August 26, 2008

RE: DW Farms Short Plat (SP-08-00021)

Holly Duncan
Environmental Health Specialist
Kittitas County Public Health
(509) 962-758

**DW FARMS SHORT PLAT**  
LOCATED IN SECTION 32, TOWNSHIP 18 NORTH, RANGE 20 EAST, W.M.  
KITTITAS COUNTY, WASHINGTON  
SP-

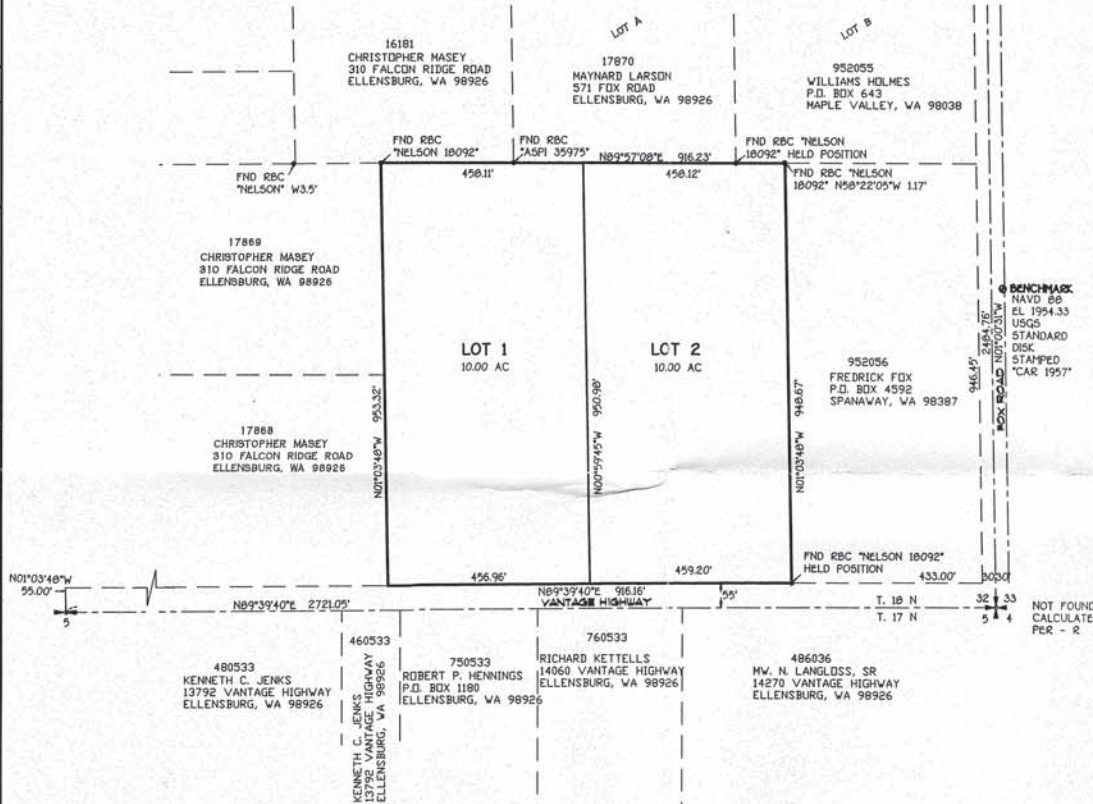
Thank you for the opportunity to comment on the above referenced project. The file indicates soil logs need to be performed and water availability information is needed. The future well(s) serving the lots will be required to have meters installed.
